KITTITAS COUNTY COMMUNITY DEVELOPMENT SERVICES

January 4, 2010

RE: Wheeler Short Plat (SP-09-00007)

The Kittitas County Community Development Services Department has determined that the Wheeler Short Plat (SP-09-00007) is a complete application and hereby grants *conditional preliminary approval* subject to the following conditions:

K.C.S.P. NO. 09-XXXXX
PTN. OF THE NE 1/4 OF SEC. 7, T.17N., R.18E., W.M.
KITTITAS COUNTY, WASHINGTON

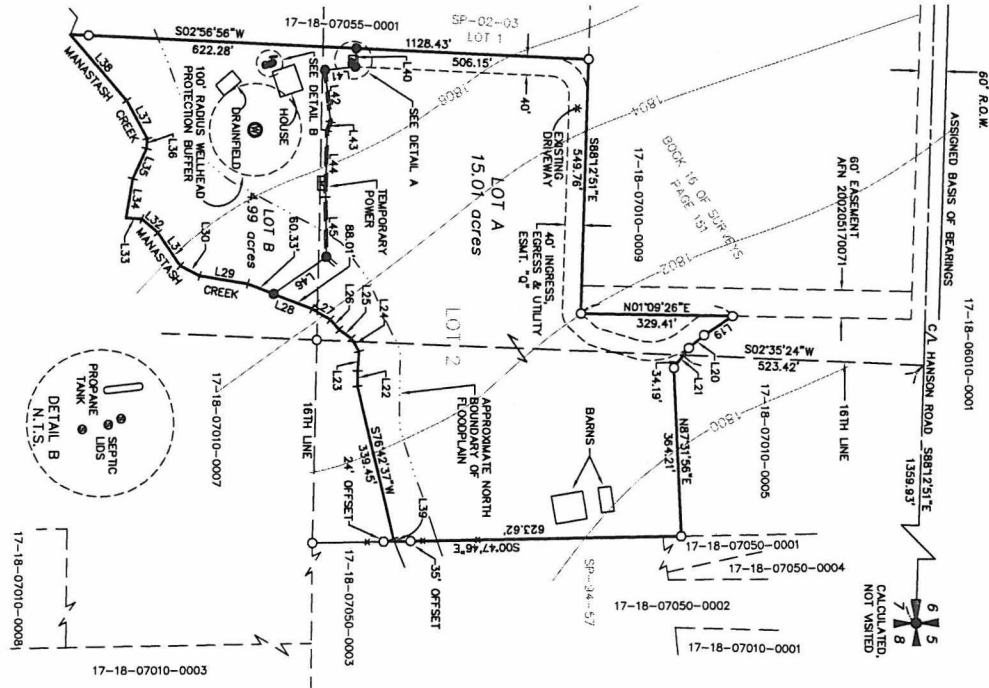
1. Both sheets of the final mylars shall reflect short plat number SP-09-00007 and an accurate legal description shall be shown on the face of the final plat.

9. Manastash Creek is identified as a Shoreline of the State, and as such is subject to the protections of KCC 17A and the Kittitas County Shoreline Master Program. A 100 foot buffer line from the ordinary high water mark of Manastash Creek shall be delineated and labeled on the final plat, and all development in the Wheeler Short Plat (SP-09-00007) shall be in compliance with applicable code.
